From: Laura Gibbons
Sent: 14 May 2018 16:06
To: Planning.Responses
Subject: RE: Planning Consultation on: BN/17/18/HH

Engineers comments in respect to surface water drainage:

APPLICATION BN/17/18/HH

Description of Works: Studio in rear garden.

Title				
Drainage Layout				
Scale	As shown	At original	A4	© Robert Clark Associates Ltd
Drawing Number	1781/D1.1			Revision
				-

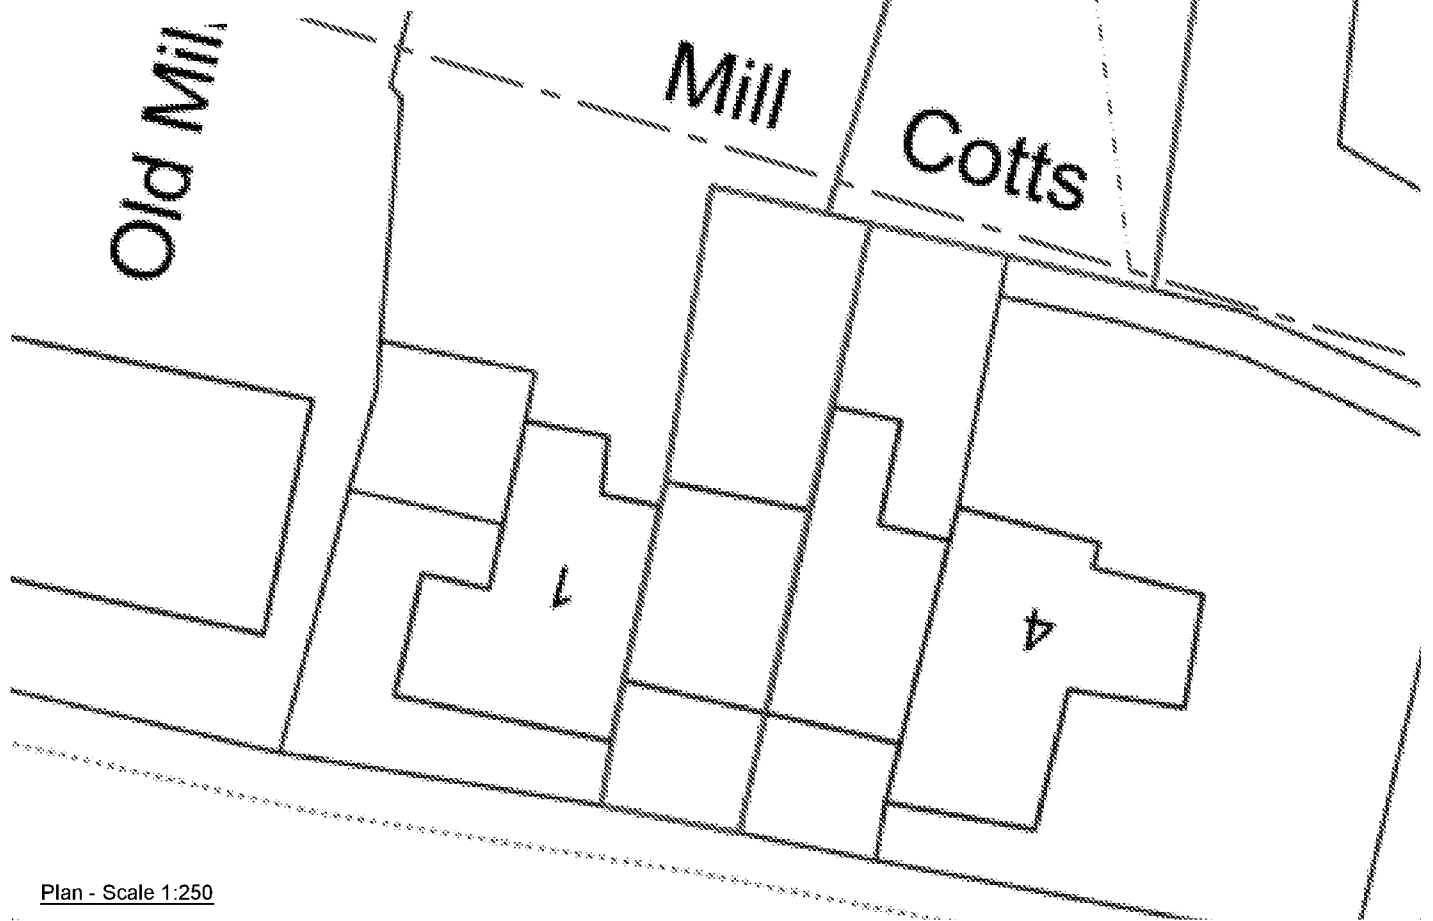
Soakaways must be investigated for surface water disposal.

Infiltration rates for soakage structures are to be based on percolation tests undertaken in the winter period and at the location and depth of the proposed structures. The percolation tests must be carried out in accordance with BRE 365, CIRIA R156 or a similar approved method and cater for the 1 in 10 year storm between the invert of the entry pipe to the soakaway, and the base of the structure. It must also have provision to ensure that there is capacity in the system to contain below ground level the 1 in 100 year event plus 40% on stored volumes, as an allowance for climate change. Adequate freeboard must be provided between the base of the soakaway structure and the highest recorded annual groundwater level identified in that location.

Any SuDS or soakaway design must include adequate groundwater monitoring data to determine the highest winter groundwater table in support of the design. The applicant is advised to discuss the extent of groundwater monitoring with the Council's Engineers. Supplementary guidance notes are also enclosed for information.

I note that percolation testing and groundwater monitoring has been completed. In addition to this and the calculations already supplied we will require a drainage layout plan, and construction details.
